From: Chris Wilson <wilson.c@optusnet.com.au>
Sent: Monday, 24 August 2020 9:32 AM
To: Andy Nixey <Andy.Nixey@planning.nsw.gov.au>
Cc: 'Brian Mariotti' <Brian.Mariotti@architectsajc.com>; 'Natasha Harras' <natasha.harras@outlook.com>; 'Peter William Scott' <peterscott@weehur.com.sg>; 'Aliza Teo Wei Meng' <alizateo@weehur.com.sg>
Subject: HPE CM: Additional Information

Council's comments re: excessive number of screens fronting Margaret Street and trees.

4 Adaptable unit 2 Post-adaptation

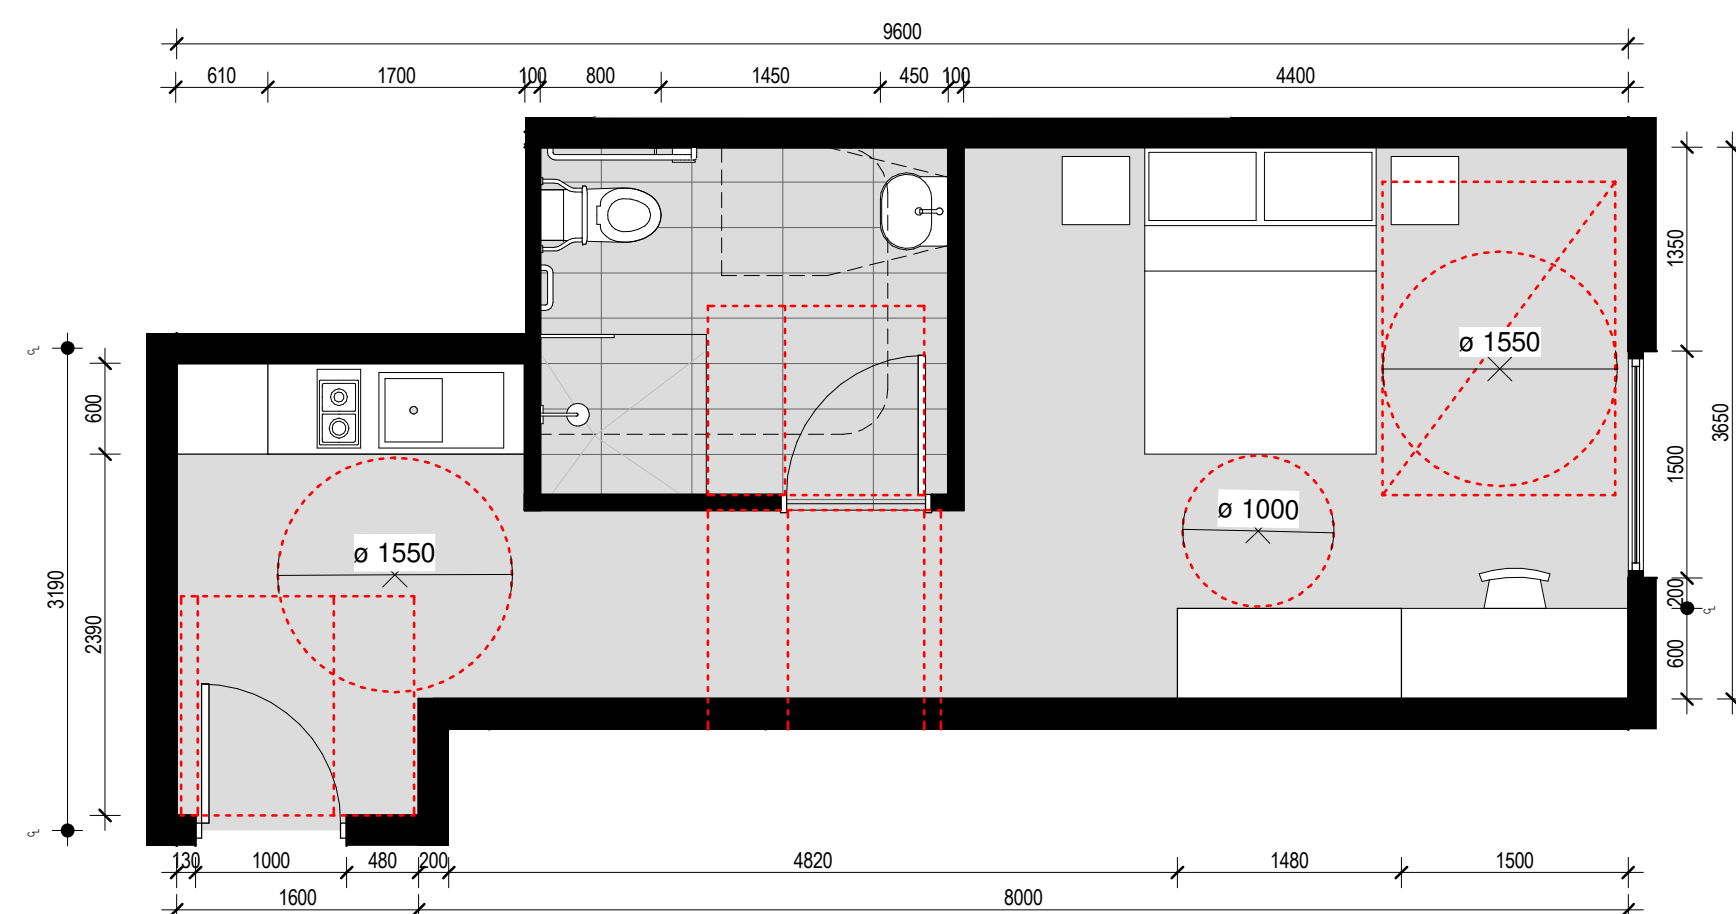
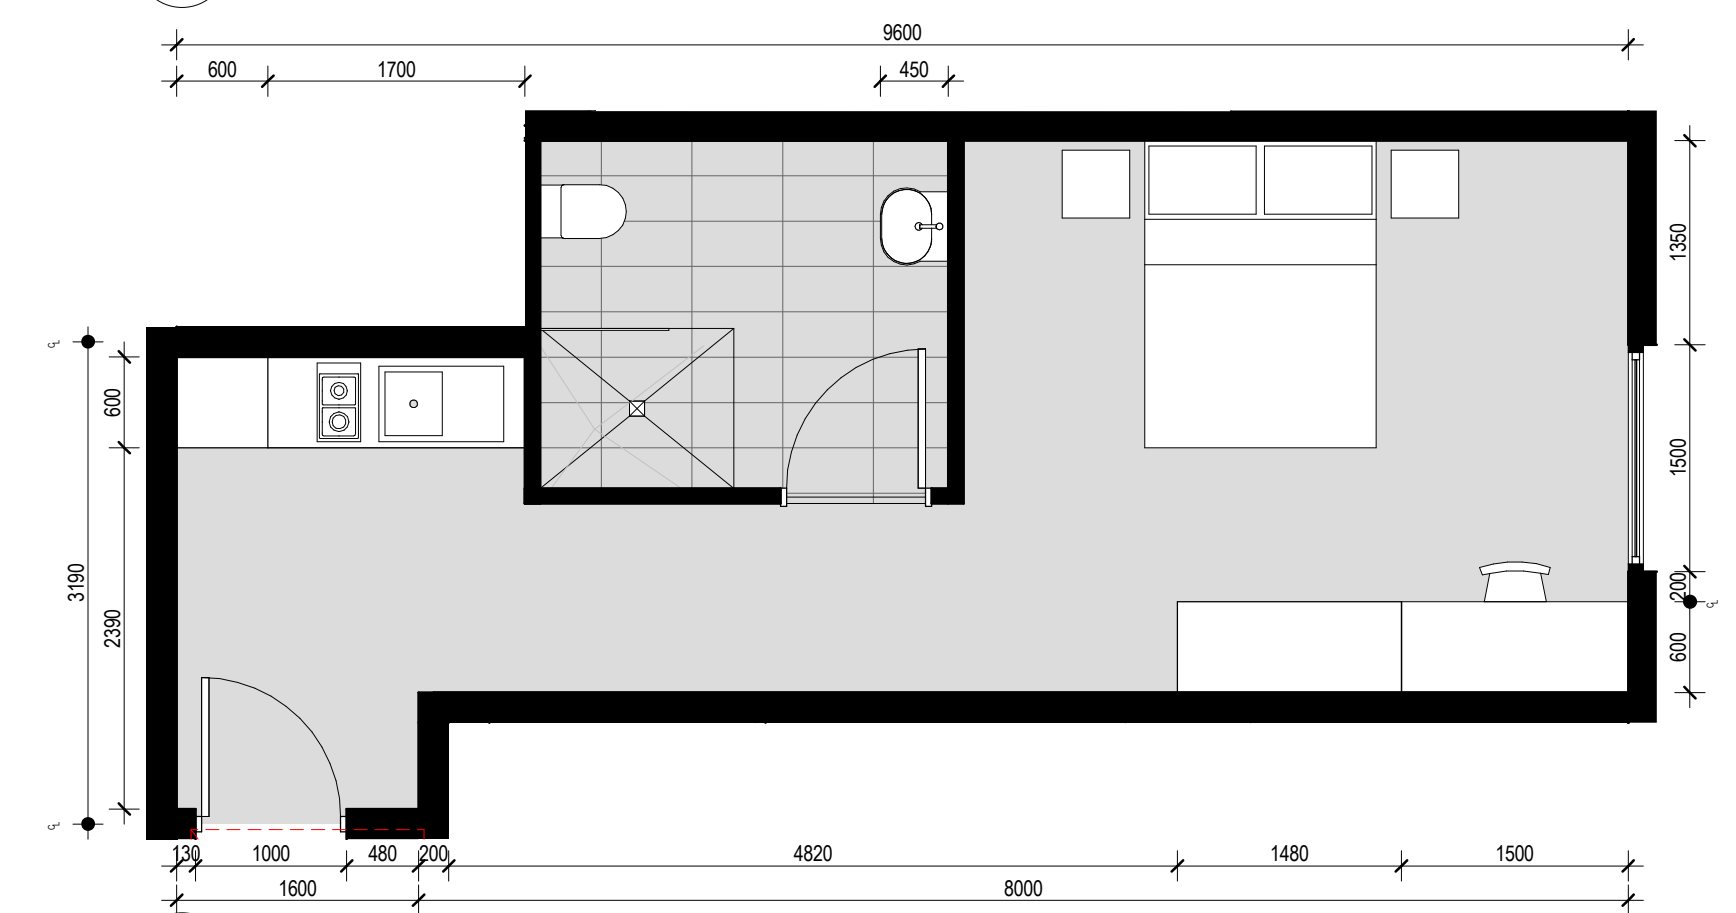
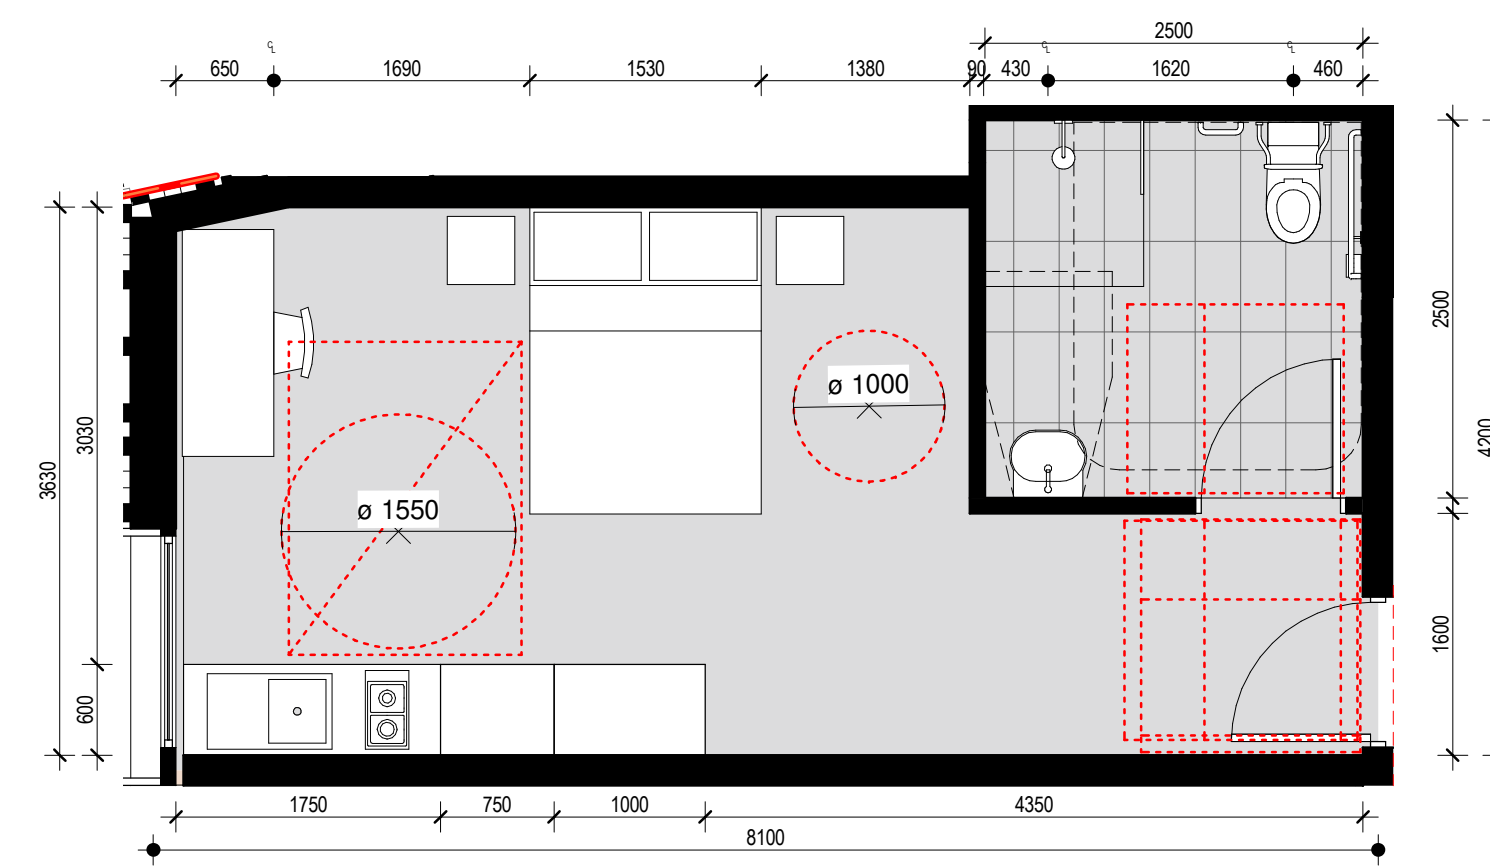
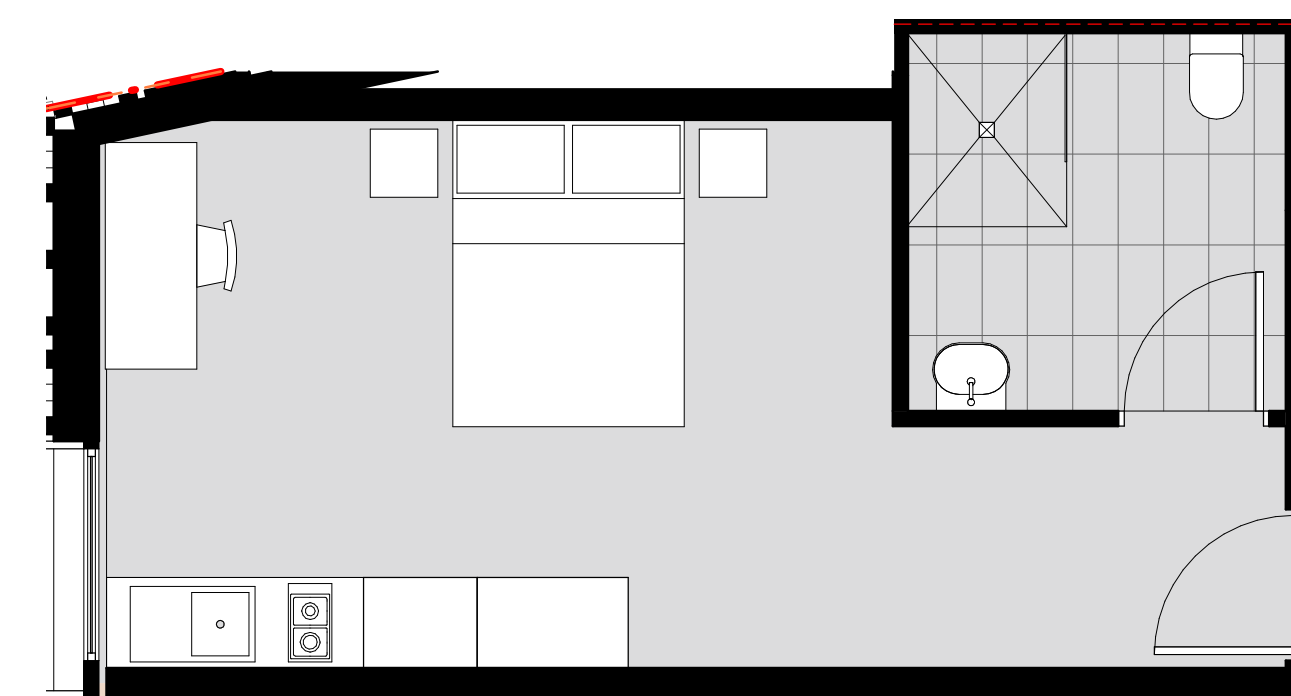
Confirm that all rooms are proposed to be for single occupants, noting the adaptable unit plans include two beds/double beds.

- Yes – All rooms are proposed to be single occupancy only. Corrected floor plans and adaptable unit plans are attached (DA2002 Rev 011 and DA5100 Rev 03) which show one bed in each room only.
